Application No: AB/98/21/HH
Site Address: 4 High Ridge Close Arundel BN18 9ES
Description of works: Erection of 2No single storey rear extensions. Conversion of roof space to habitable use to include 2No front and 1No rear flat roof dormers. Increased width of existing vehicular crossover and 1No additional crossover. Gabled canopy to front entrance and removal of chimney.

Objections & comments to proposed extensions and alterations.

No 4 High Ridge Close Arundel Sussex BN18 9ES

Ground floor plan 1:100 @ A3

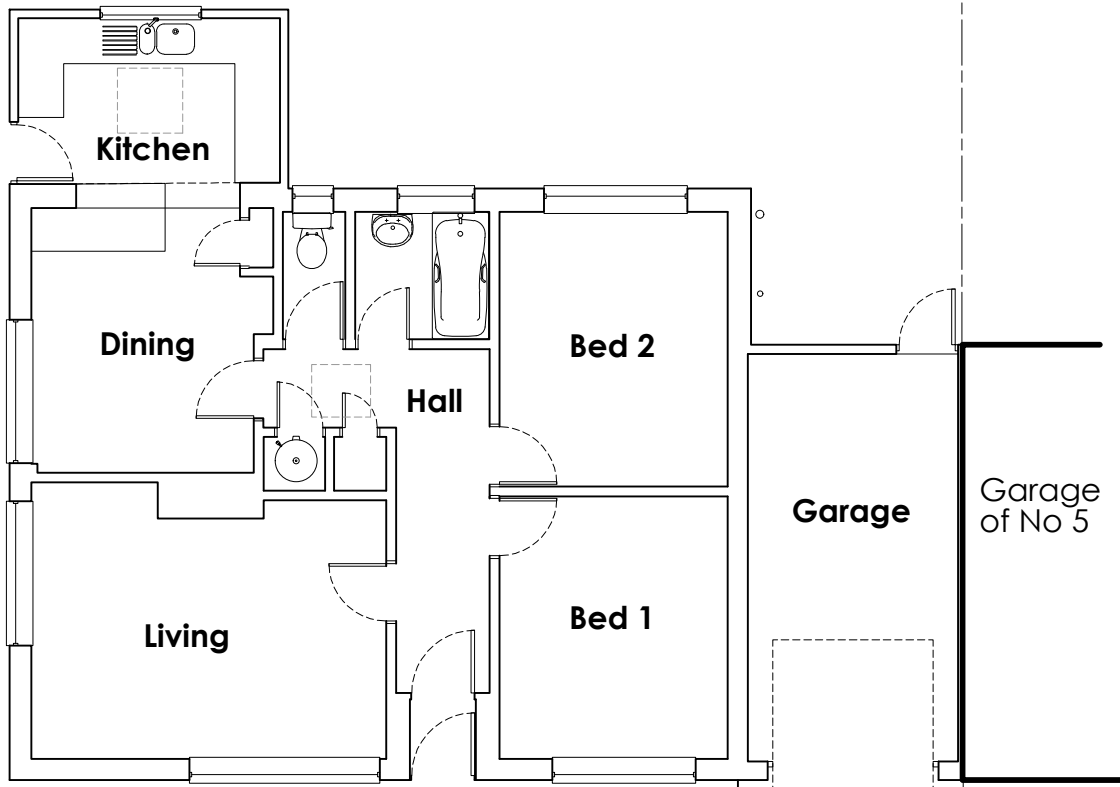
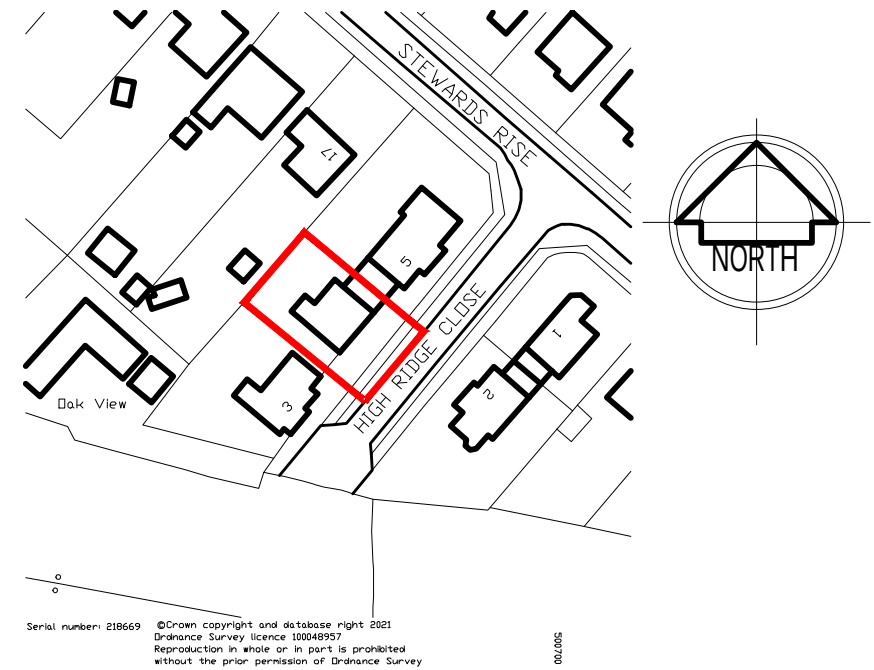
The proposed development indicates the creation of a balcony above the ground floor extension, it is unclear from the plans and elevations if the intention of the balcony as described relates to a 'Juliet balcony', without access onto the flat roof area or if the door from the bedroom would allow access. If the roof is intended to

provide a balcony with access, the plans (04 July 21) are misleading as they do not include a compliant handrail. The addition of a balcony and handrail on the top of the 1st floor extension will create an immediate high vantage point for the occupants of No 4 to look directly into the private rear garden of No 5 to the east of the site. The proposed development should be amended to clarify this point and the plans and elevation amended.

We request that any planning application would be revised to remove the balcony and that Arun District Council add a condition that would prevent current and future occupants or owners from creating one at a later date.

The proposed use of the garage extension is not on the plan, add to application.

We request that our West boundary wall connecting the rear of the garage to the North boundary be left in position to form a legal boundary between the properties, add to application.

We request that a min gap of 40cm be left between our garden boundary wall and the East facing garage extension wall & roof overhang for maintenance access, add to application.

Block & Site plan 1:200 @ A3

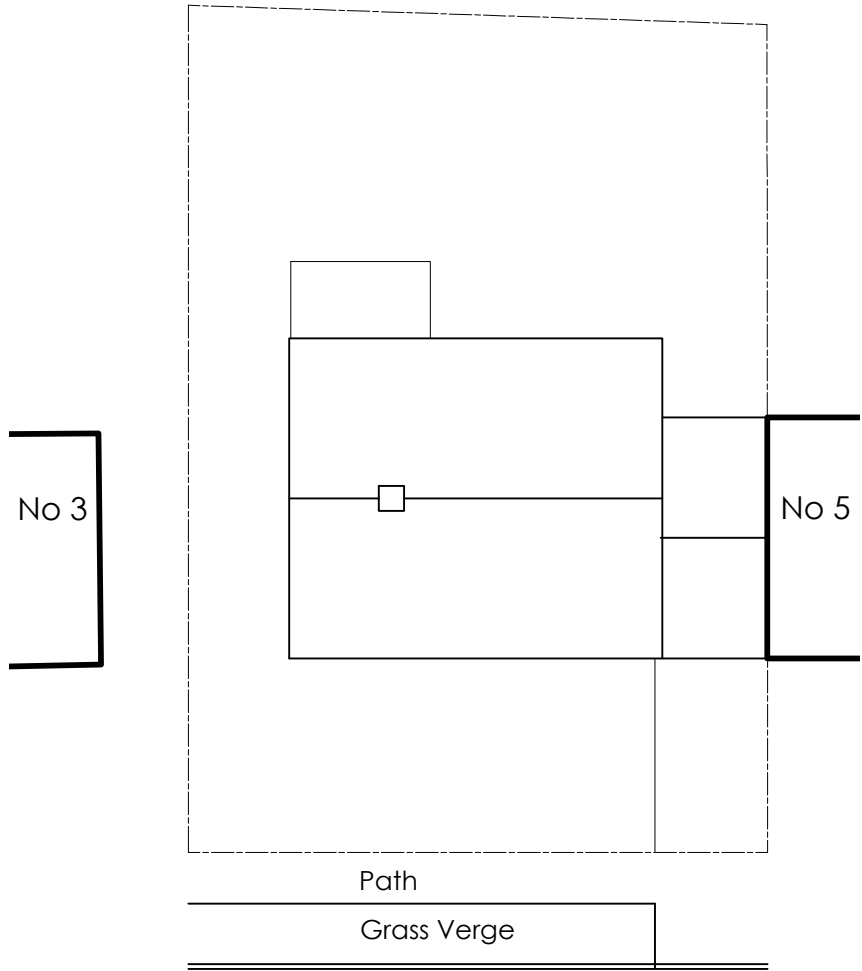
The shared rainwater drainage from the roof of the garages is at present linked with No 5 and connected to a soakaway positioned in the garden of No 4, under the garage extension. It should be a condition of the approval that the rainwater drainage design complies with the appropriate authority, prior to commencement of works, to ensure that the design can accommodate the existing shared and additional discharge created by the works and provision can be made for a new soakaway in the garden of No 4.
